CITY COMMENTS. 12/20/15

72 BISHOP STREET
Portland, Maine
Bishop Street

Title: SUBDIVISION PLAT PLAN

Title: SUBDIVISION PLAT PLAN

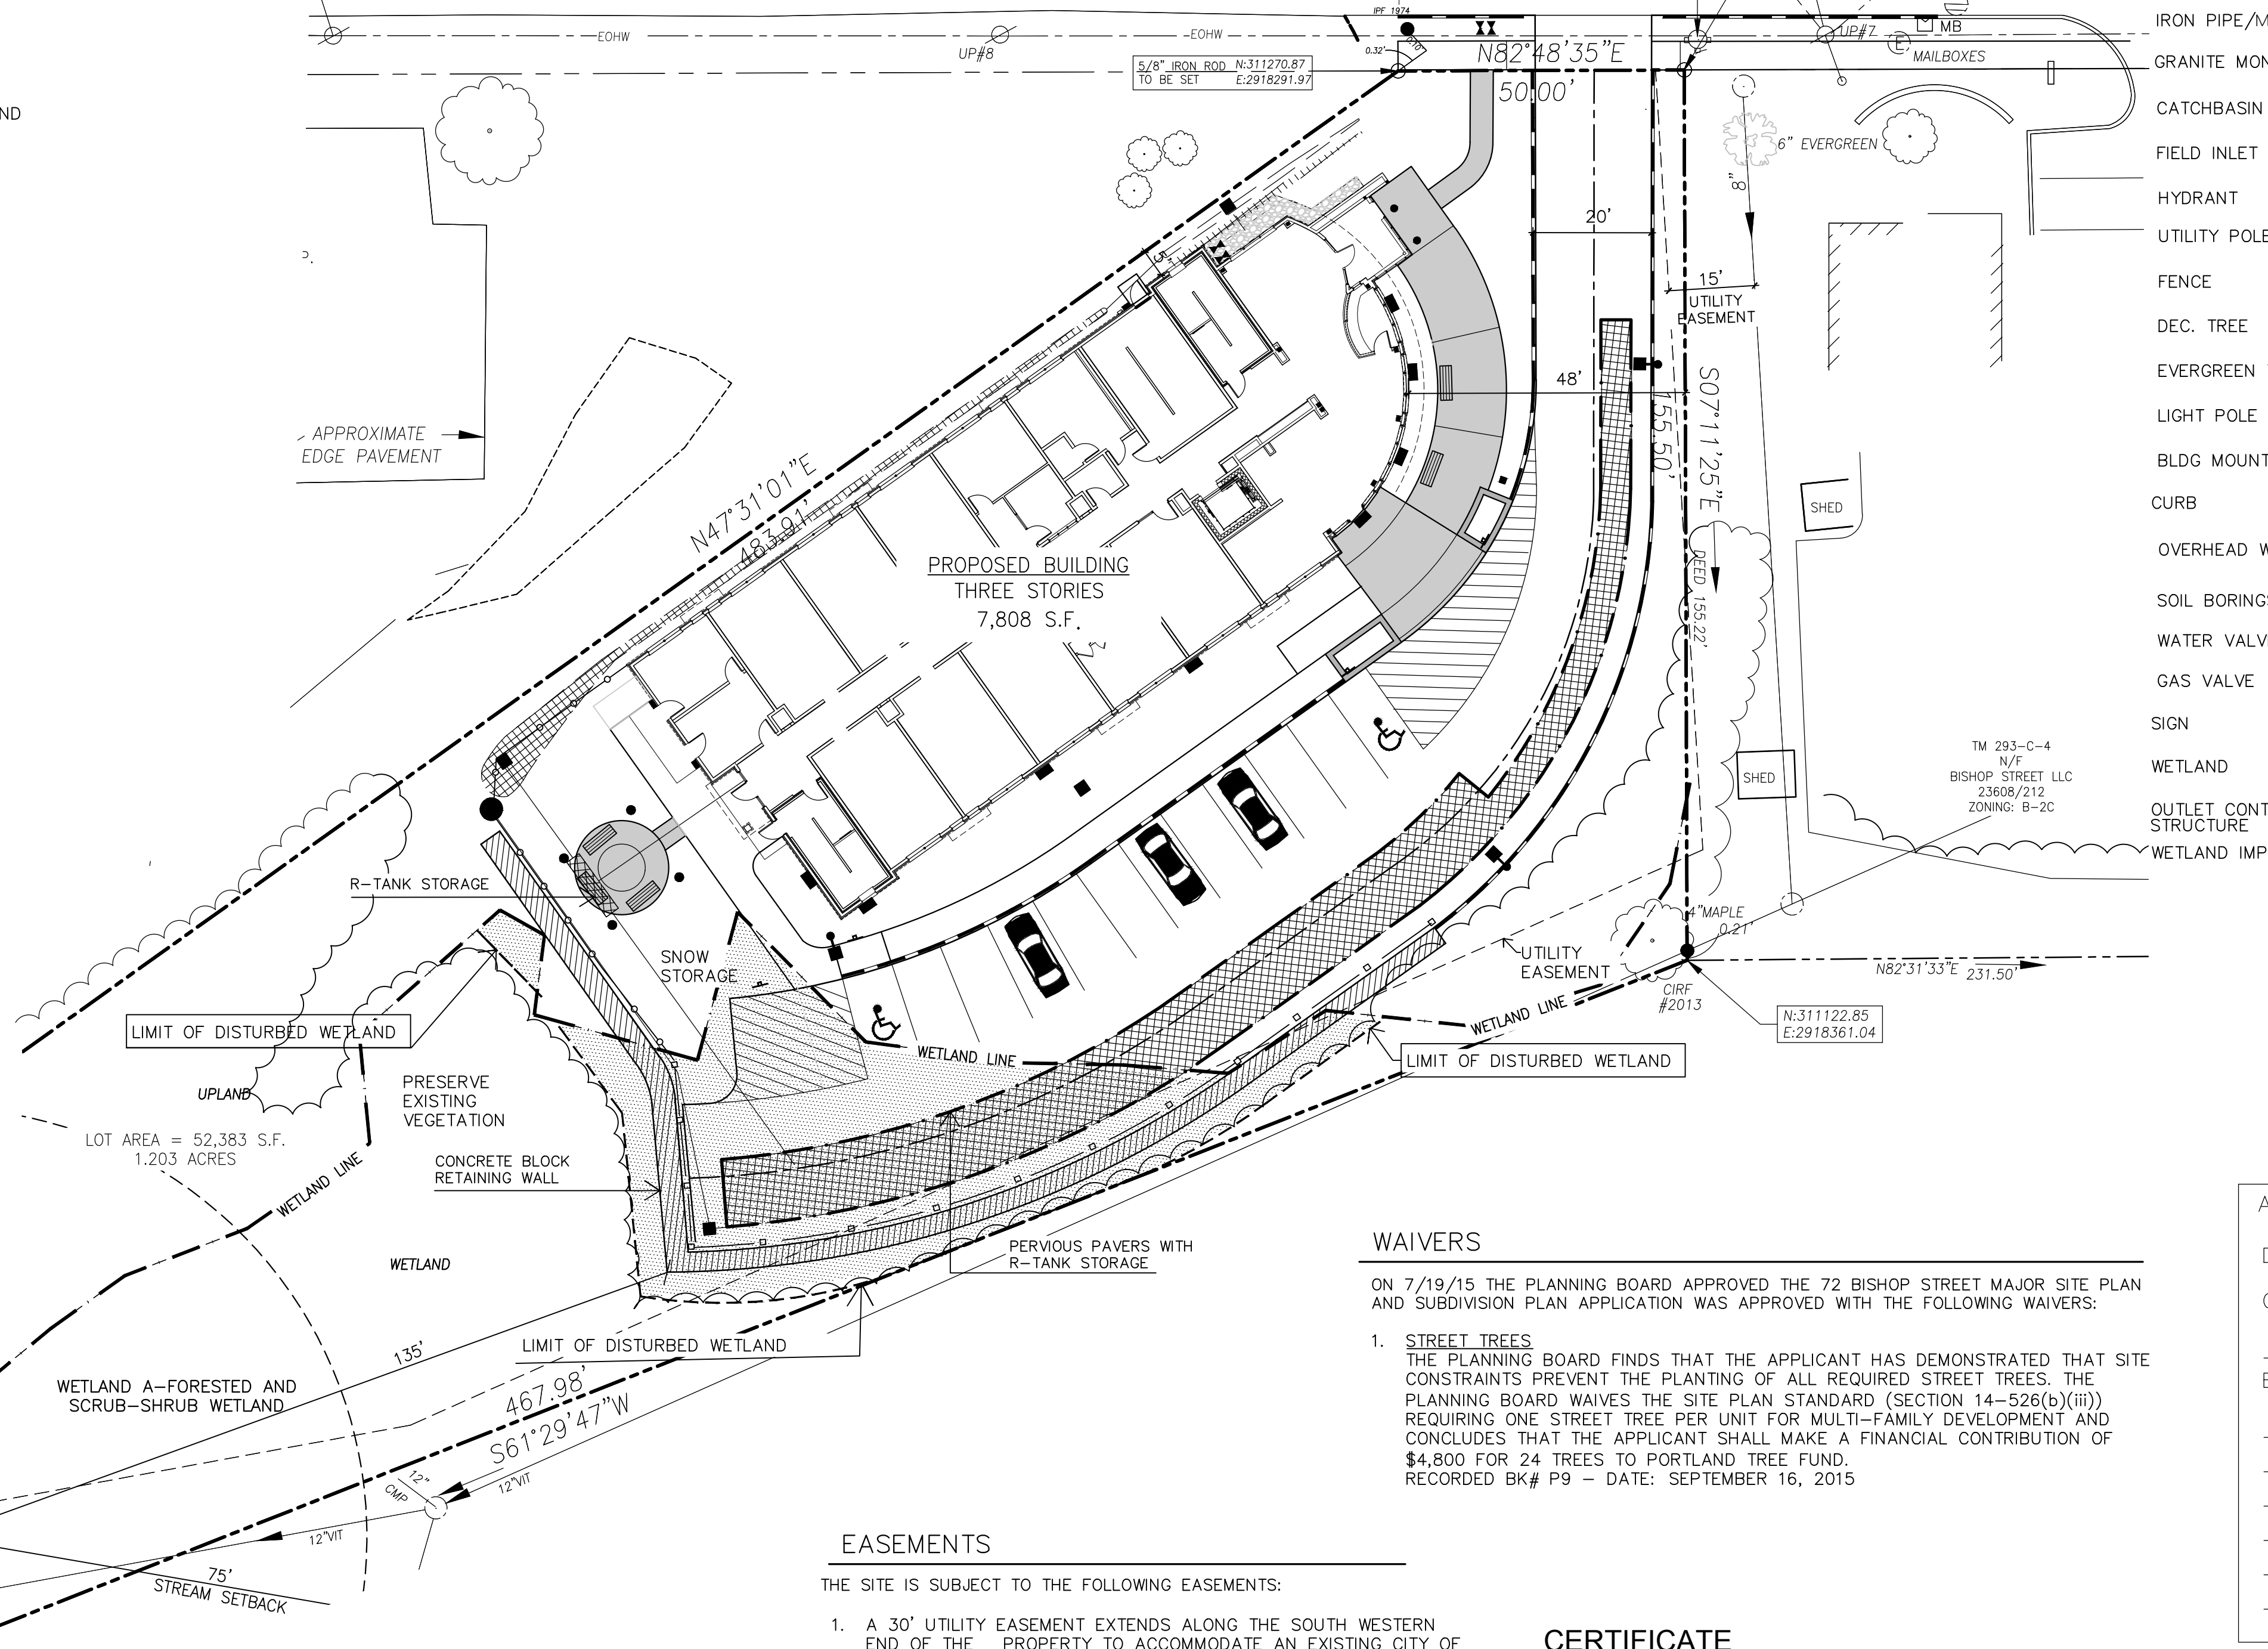
- THE DEVELOPMENT PROPOSED AT 72 BISHOP STREET REQUIRES THE FOLLOWING PERMITS:
1. NRPA PERMIT BY RULE NOTIFICATION WETLAND ALTERATION DATED JULY 30TH 2015
 2. GENERAL CONSTRUCTION PERMIT ... (UNLESS THIS APPLIES?)

CITE REST OF CONDITION, INCLUDING REFERENCE TO MAINT AGREEMENT AND LEAVE SPACE FOR BOOK TABLE
